Submission and Objection to SSD 10321-Mod2 89 John Whiteway Drive Gosford – 12 April 2021

As a non-resident owner of an apartment in SP53908 117 JWD I should like to re-iterate objections raised in previous submissions dated 20.5.2020 and 27.4.21 - particularly that of **Excavation extending into the 'non buildable areas'**

PLAN SHOWING BOUNDARIES, RELATIVE HEIGHTS & PHYSICAL FEATURES OVER LOT 100 IN D.P. 1075037 & LOT 1 IN D.P. 45551 KNOWN AS No. 89 JOHN WHITEWAY DRIVE, GOSFORD.

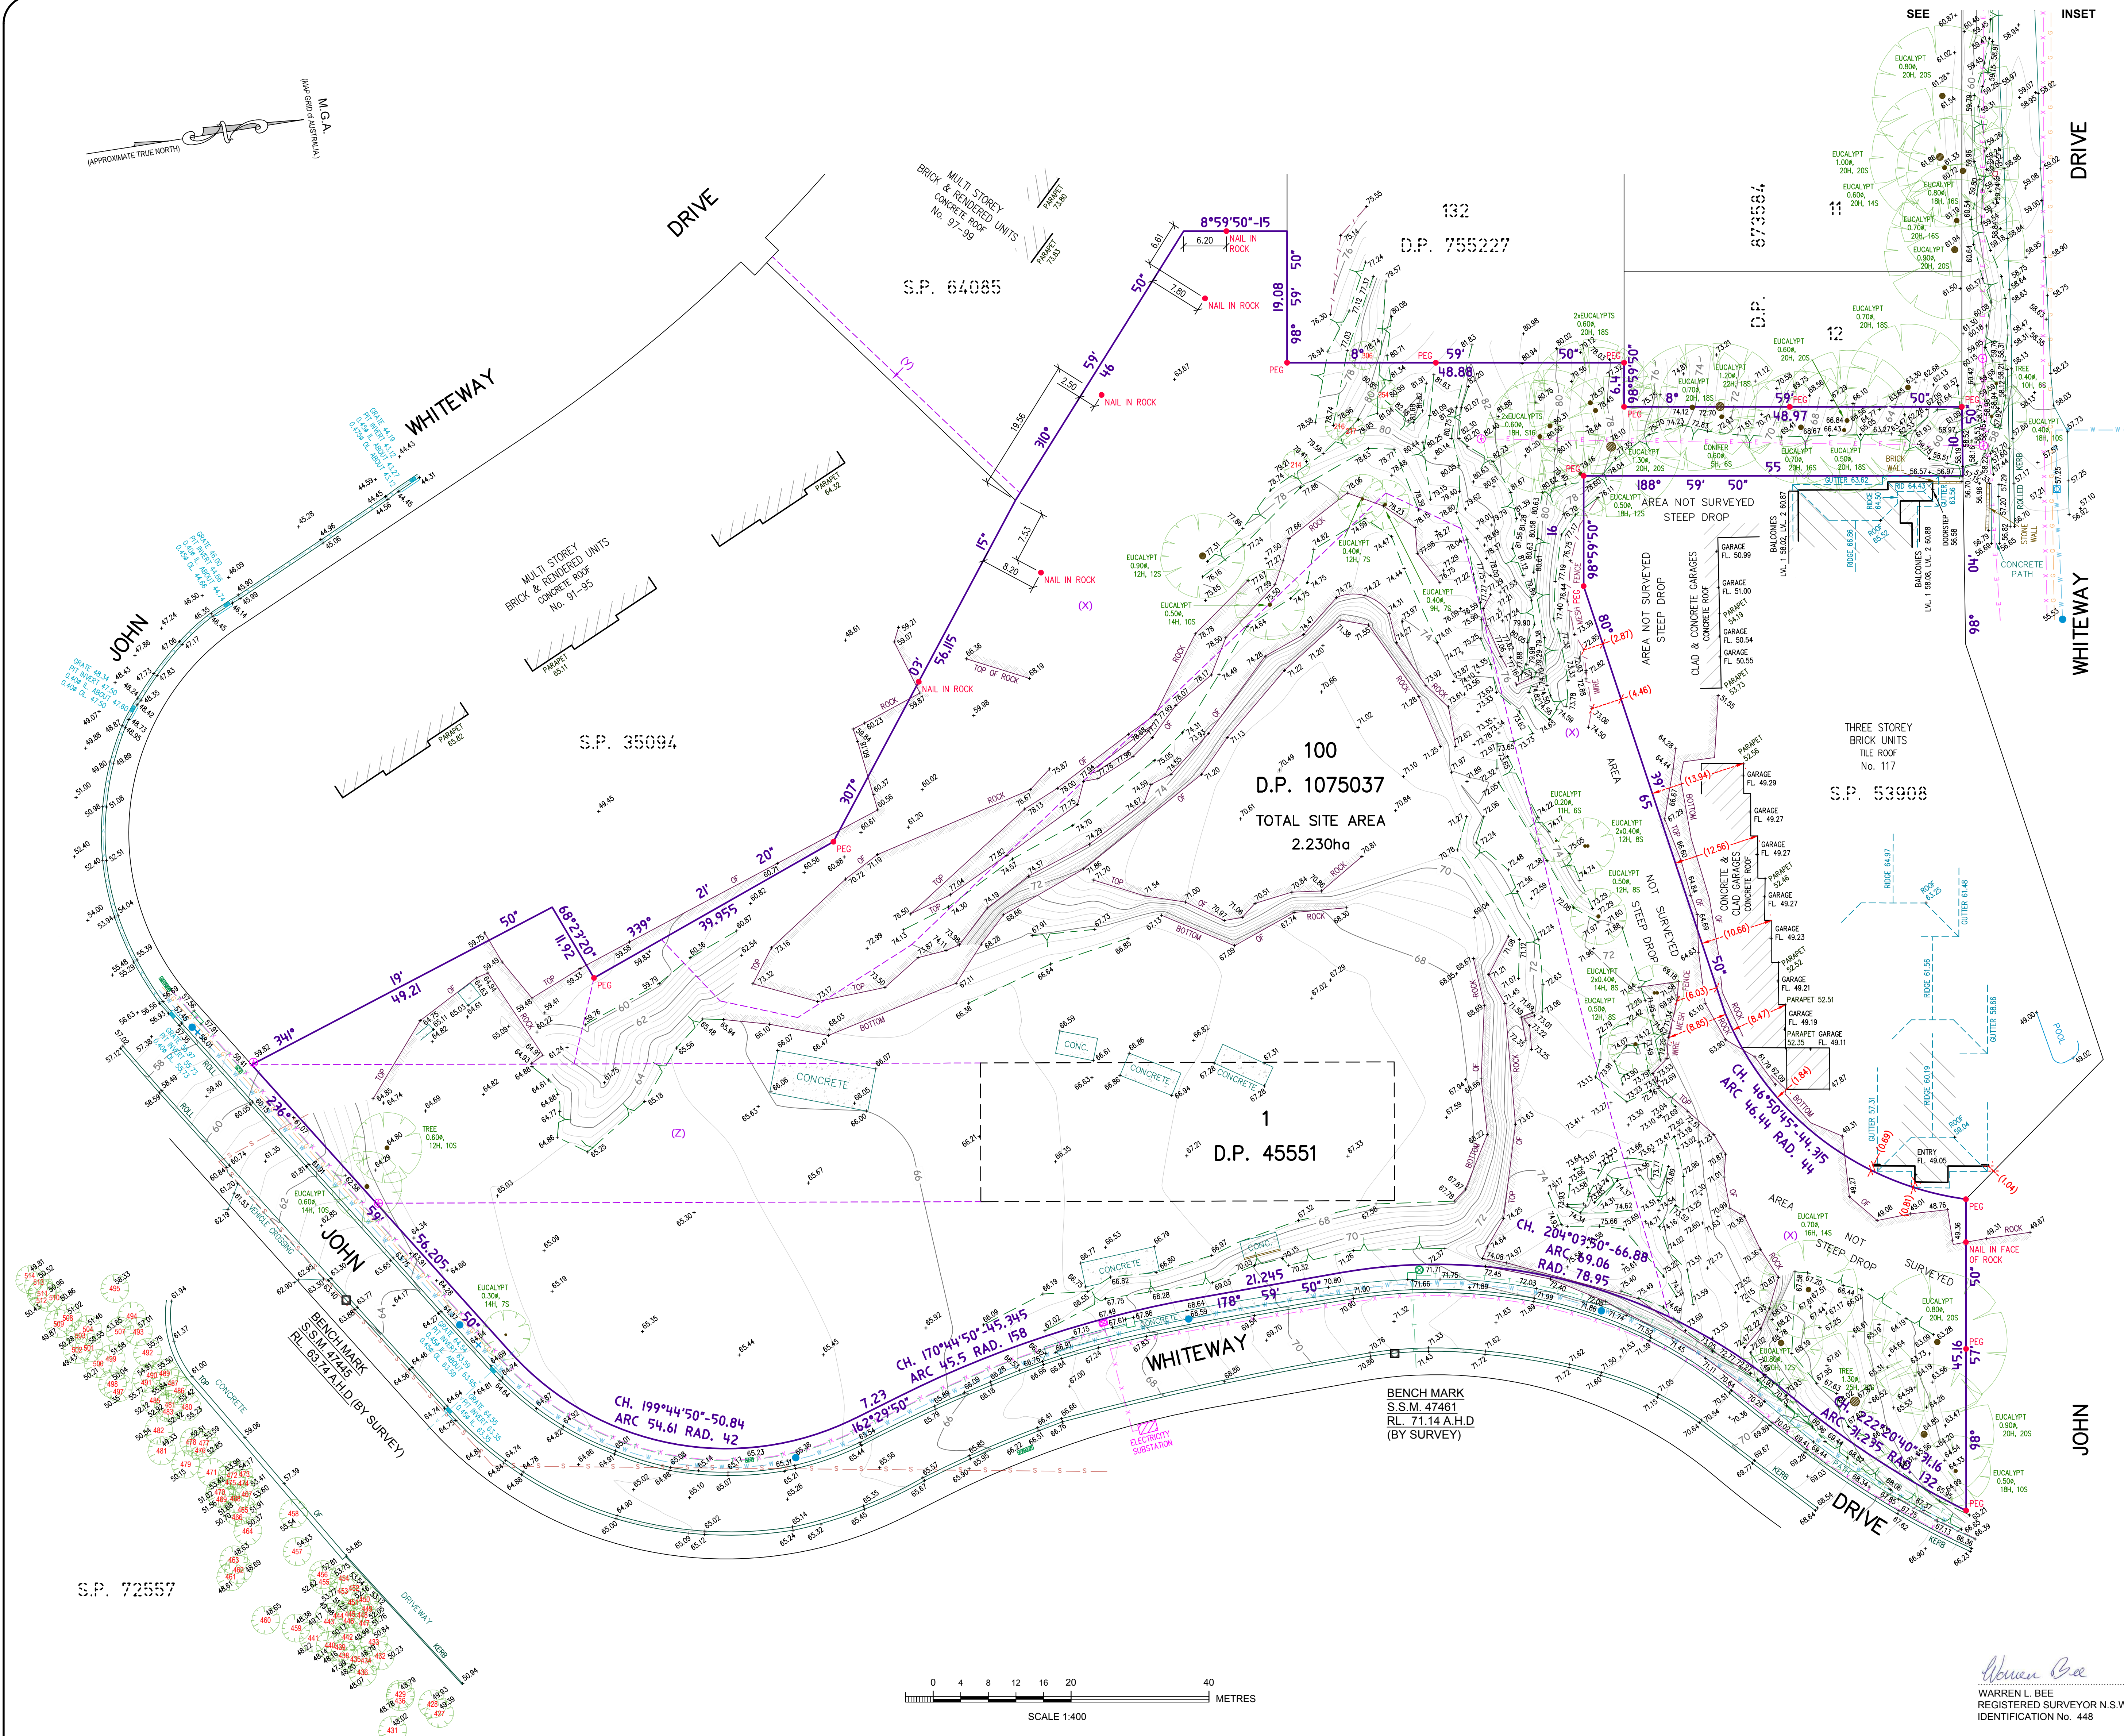
On the NE side of the Site *over-excavation extends to within a couple of meters of the Ridgeline* – less than 20M from our garages and opposite U1/117 – See attached photo of the SE corner of SP53908 Units 1, 2 & 3 and the Old Gosford Quarry *vertical cliff face* several meters away. This cliff face is shown as "Area not surveyed – Steep Drop" in the Pinnacle Construction Survey DWG 20770 dated 7.11.17 which is attached.

NB. 117 JWD buildings appear to almost touch their boundaries at their eastern and western edges. Roof *Ridgelines* vary in height from **60.19M** at their eastern end to **66.86M** at the western end. (Ref. Pinnacle Construction Survey DWG 20770 dated 7.11.17).
